The Sizewell C Project

Natural England's response to the Examining Authority's request for further information (*Sizewell - Rule 17 request for information*, letter dated 1st October 2021 and *Sizewell C - Rule 17 request for information by Deadline 10*, letter dated 6th October 2021)

Planning Inspectorate Reference: EN010012

12th October 2021

SECTION B - B
SCALE 1:200

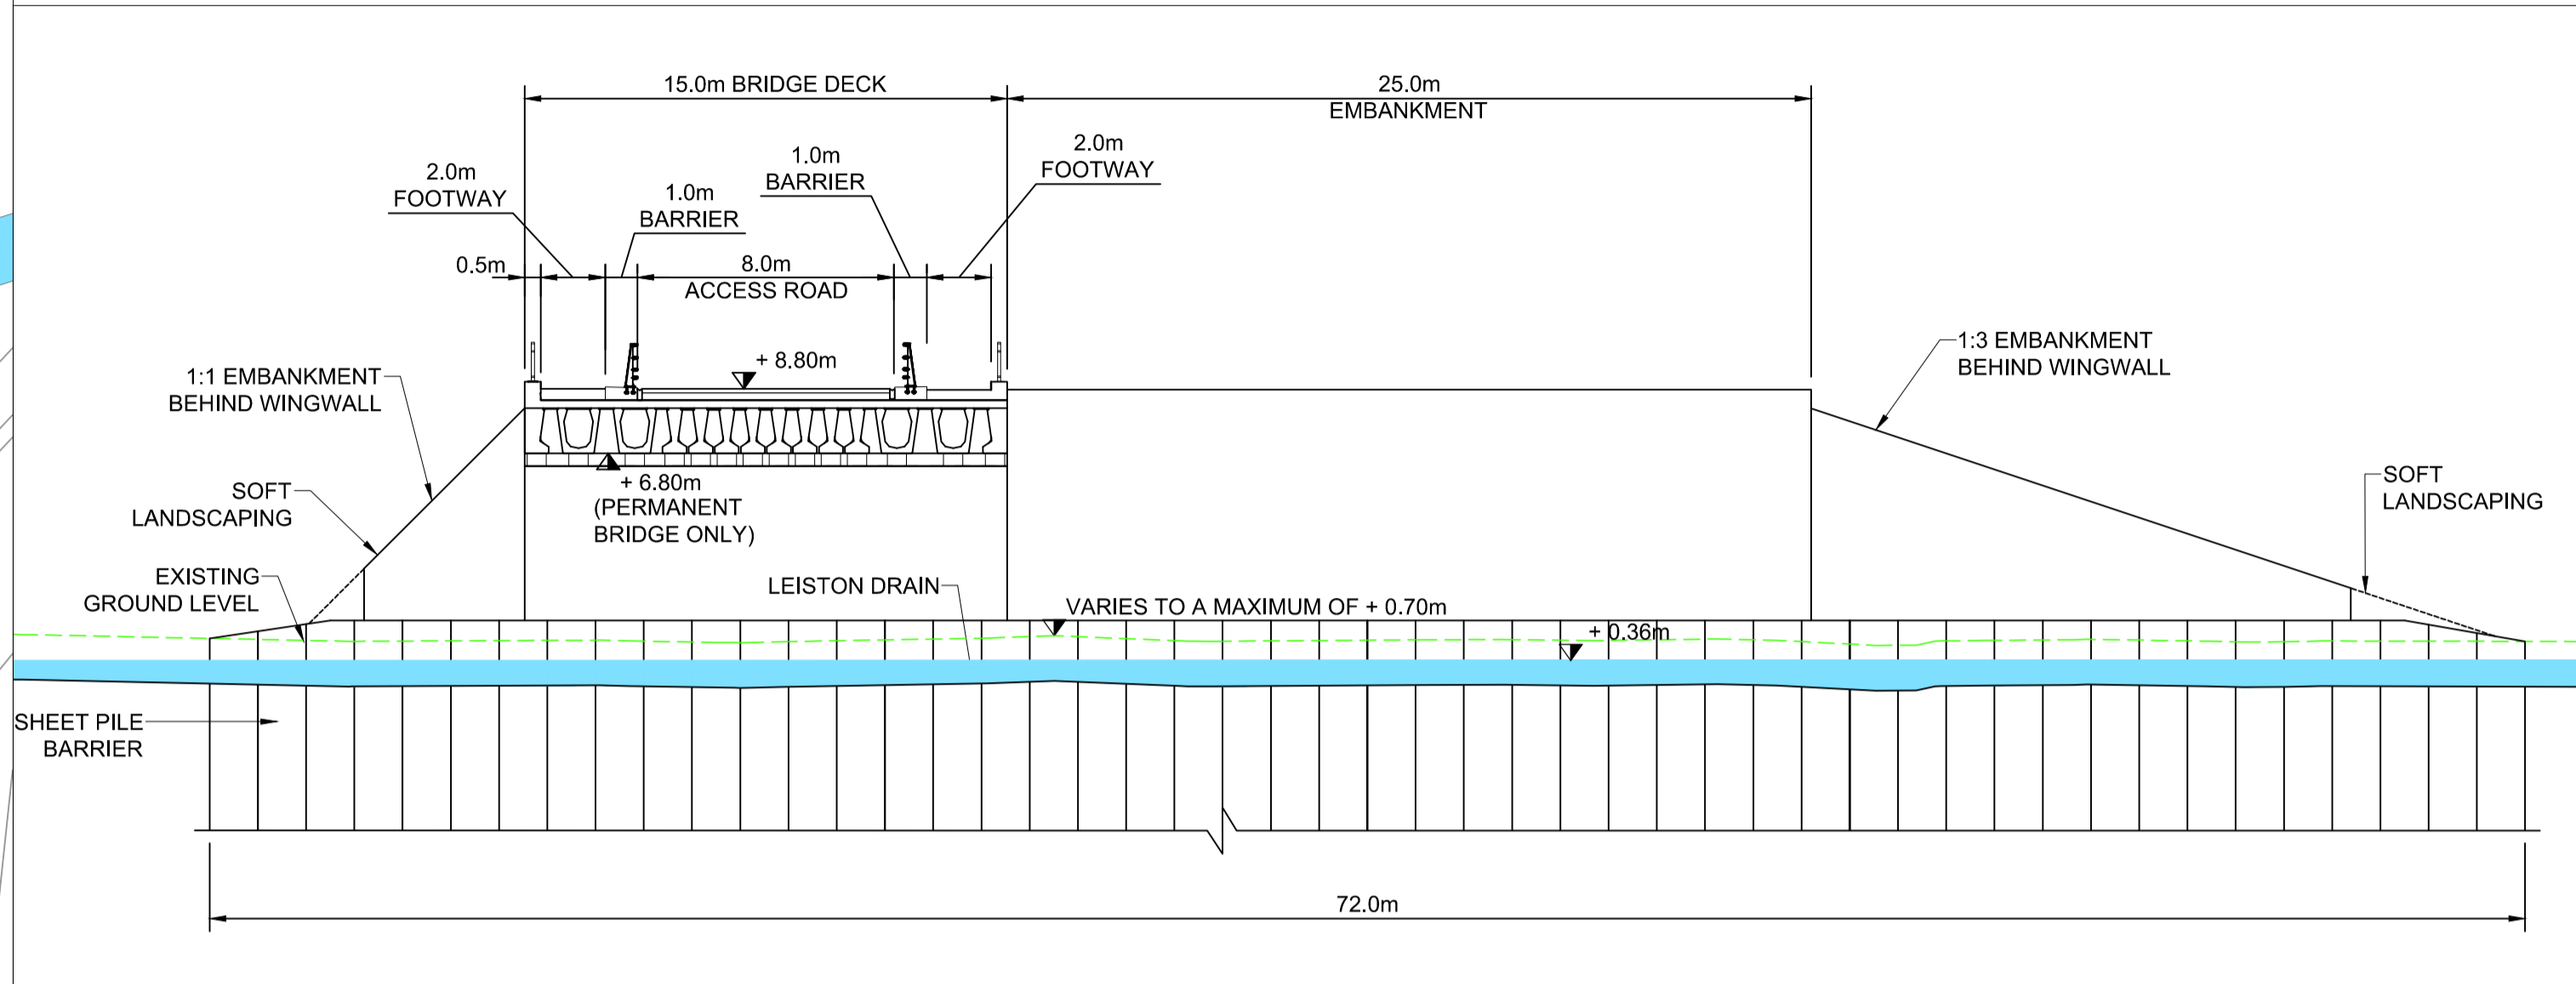
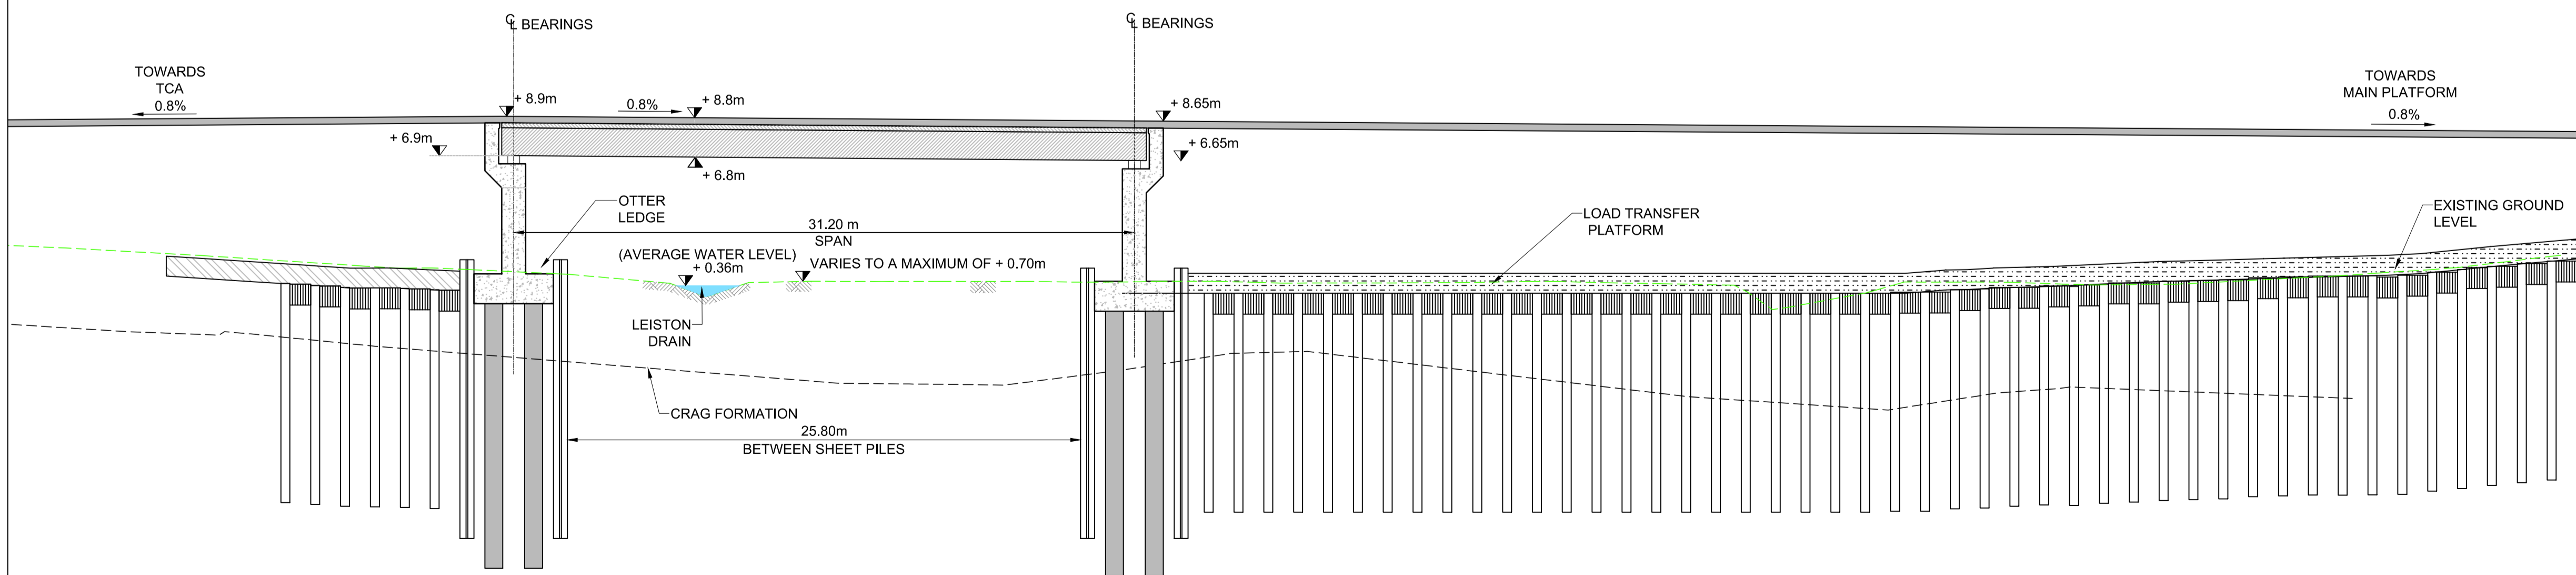
13	<p>Issue 48 – SSSI crossing effect on tall herb fen and lowland ditch systems. Natural England are recorded as being of the view in August – the latest view expressed - that should the current design and the new mammal culvert be considered justifiable against possible alternatives the quantity and quality of tall herb reed fen and lowland ditch systems created at Aldhurst Farm satisfy them “in principle”. Please can SoCG record what Natural England consider to be the possible alternatives.</p>	<p>The latest comments from Natural England on this issue within our SoCG (August 2021) is as follows:</p> <p><i>We welcome the continued optimisation of the SSSI crossing design and that while our preference remains for a three-span bridge we acknowledge that the current design represents a best alternative. However, this issue will remain ‘amber’ as we still believe that the three-span bridge design will have the least impact ecologically on Sizewell Marshes SSSI.</i></p> <p><i>We also welcome steps taken to increase connectivity between Aldhurst Farm and Sizewell Marshes SSSI using a mammal culvert.</i></p> <p><i>Should these be considered justifiable against possible alternatives, then we are satisfied ‘in principle’ with the quantity and quality of tall herb fen (reedbed) and lowland ditch systems created as compensation at Aldhurst Farm.”</i></p> <p>To clarify, the ‘possible alternatives’ as outlined above refers to the three-span bridge design option presented in pre-application for the SSSI crossing itself rather than the mammal culvert on Lover’s Lane. Natural England reiterate our point made above and throughout our pre-application advice, Relevant and Written Representations with regards the SSSI crossing design proposals against possible alternatives.</p>
